KITTITAS COUNTY COMMUNITY DEVELOPMENT SERVICES

RE: Dunford Barn Boundary Line Adjustment (BL-23-00004) - Deemed Incomplete

Determination of Incompleteness: This determination is based on wetlands not being identified on site plan/survey per KCC 16.10.020(3) and KCC 15A.03.030(2).

DUNFORD BARN
 PROPOSED RECREATION AREA
 NAME
 PT NW1/4 SEC.3 T19N,R17E & PT SW1/4 SEC.27 & W1/2 SEC.34, T20N,R17E, W.M.
 DRAWING TYPE
 RECORD OF SURVEY
 PARCEL NO. 961865/961866 SCALE: 1"=600'
 MAP I.D. 20-17-34050-0006 ET AL DATE: 04/03/2023
 SHEET 1 OF 2
 SHEETS 2
 PROJECT
 22012

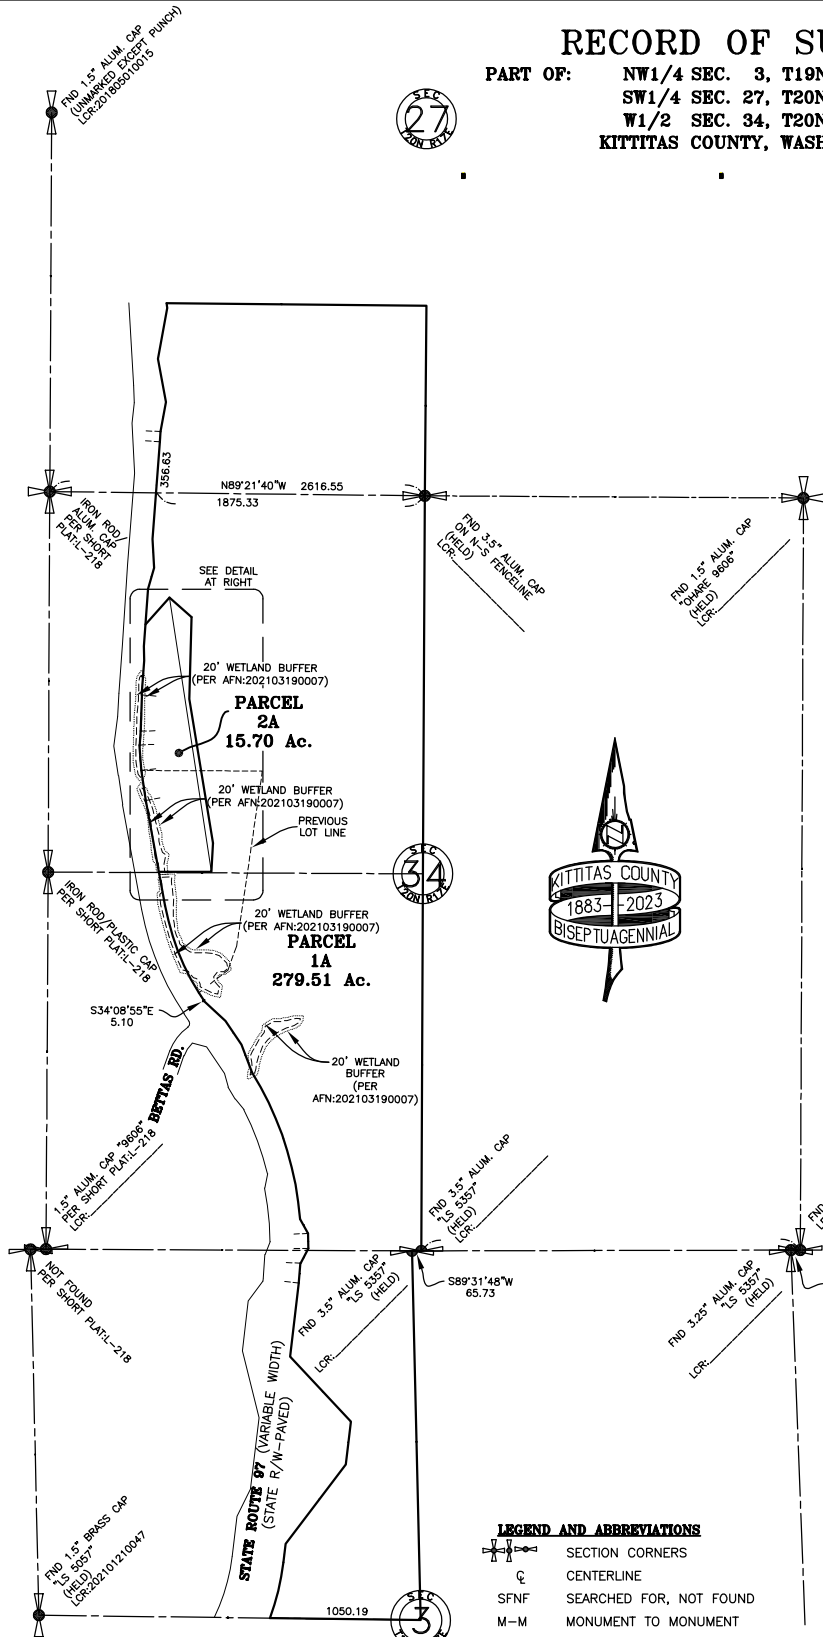
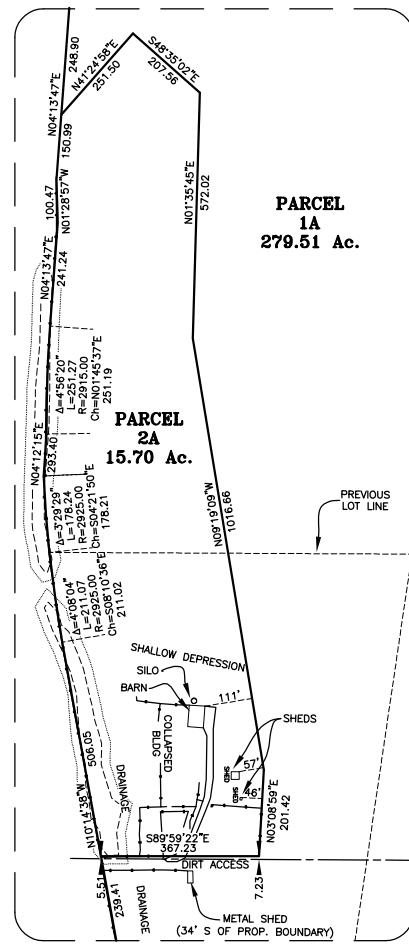
1. Please update the Site Plan/Survey to show the wetlands on these properties. This information can be found on the recorded Dunford Large Lot Plat (SPF-20-00002) also under Auditor's File Number 2021031190007. This plat references the critical areas report done by Mr. Sewall of Sewall Wetland Consulting Inc. under file No. Dunford #A7-169 dated February 1, 2010. Staff has enclosed a copy of this report and recorded plat for reference.
